CITY OF ALBUQUERQUE

July 6, 2021

**RE: San Roque / La Serena
441 & 457 Coors Blvd NW
Grading & Drainage Plan and Drainage Report
Engineer's Stamp Date: 06/10/21
Hydrology File: J10D049**

Based upon the information provided in your submittal received 06/10/2021, the Grading & Drainage Plan and Drainage Report **are not** approved for Building Permit and action by the DRB on Preliminary Plat or Site Plan for Building Permit. The following comments need to be addressed for approval of the above referenced project:

STORM DRAIN MAP AND HYDRAULICS CALCULATIONS

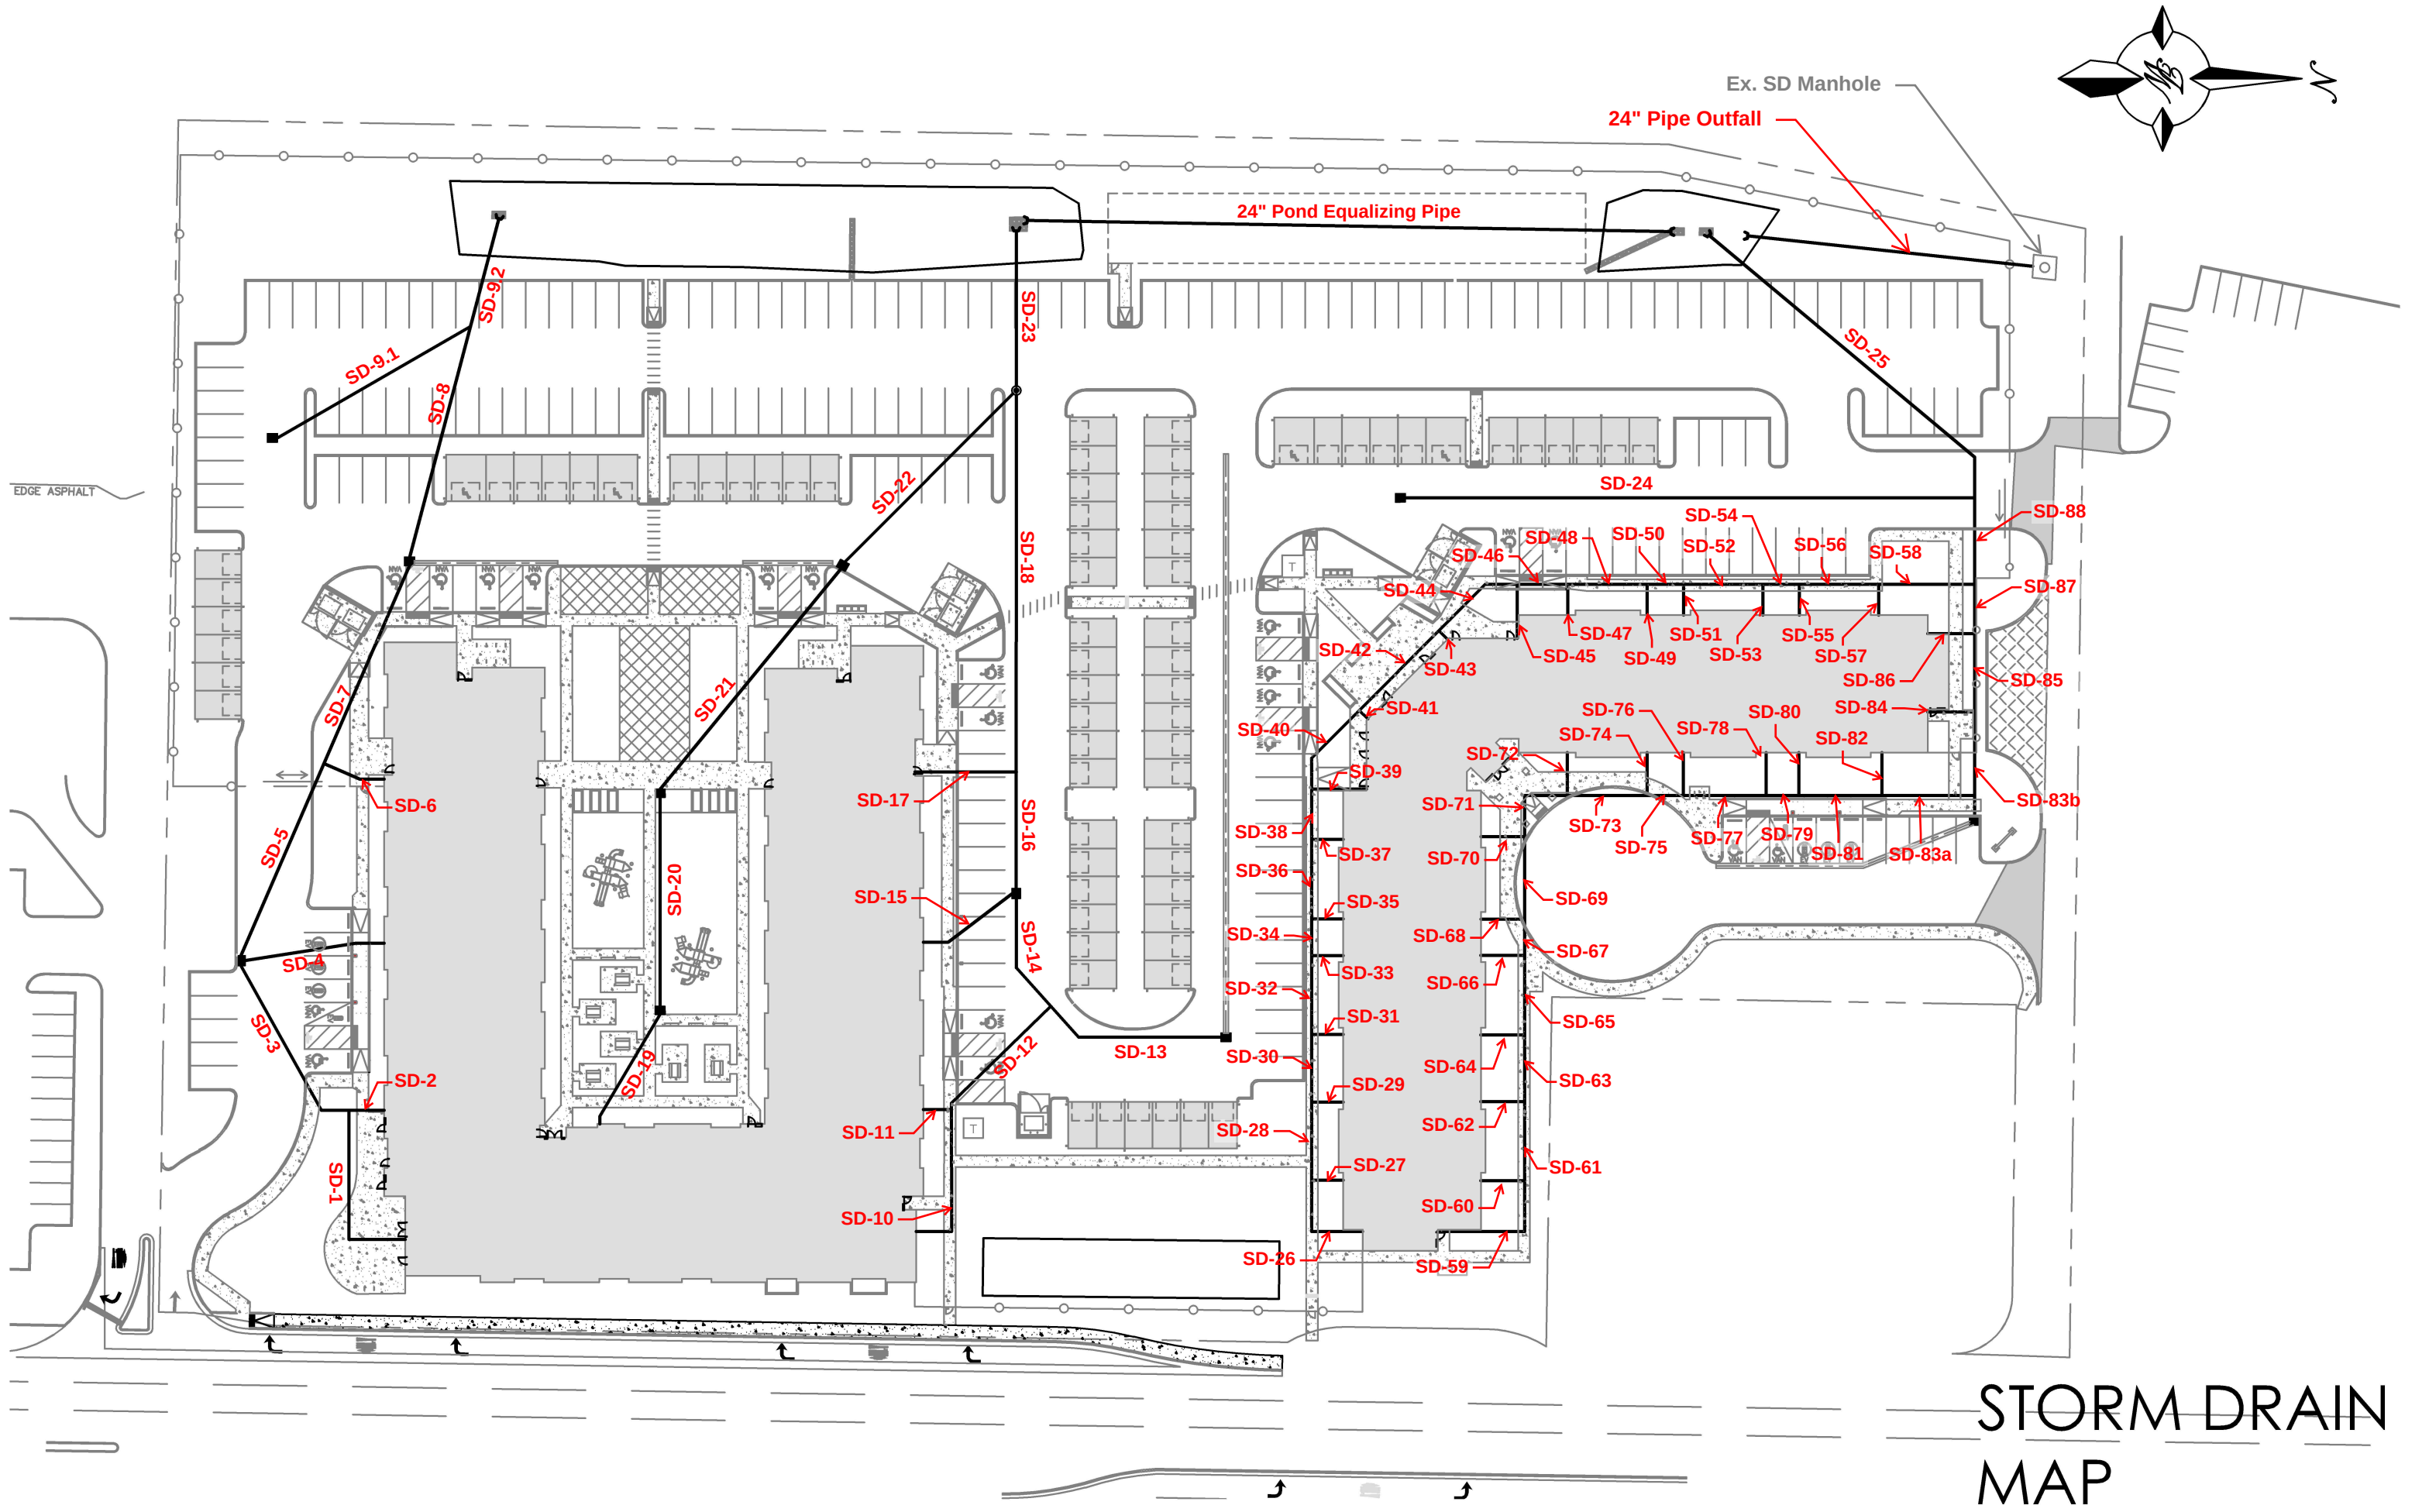
8. Sheet 2.3. Depending on the new design, this storm pipe layout may change.
9. Sheet 2.4, 2.5, & 2.6. Please change the title from “Grading Details” to “Grading Enlarged Area”. Also on Sheet 2.0, please show the these areas and label them to go to the correct sheet.
10. As a reminder, if the project total area of disturbance (including the staging area and any work within the adjacent Right-of-Way) is 1 acre or more, then an Erosion and Sediment Control (ESC) Plan and Owner’s certified Notice of Intent (NOI) is required to be submitted to the Stormwater Quality Engineer (Doug Hughes, PE, jhughes@cabq.gov , 924-3420) 14 days prior to any earth disturbance.
11. Standard review fee of \$300 (for DRB Site) will be required at the time of resubmittal.
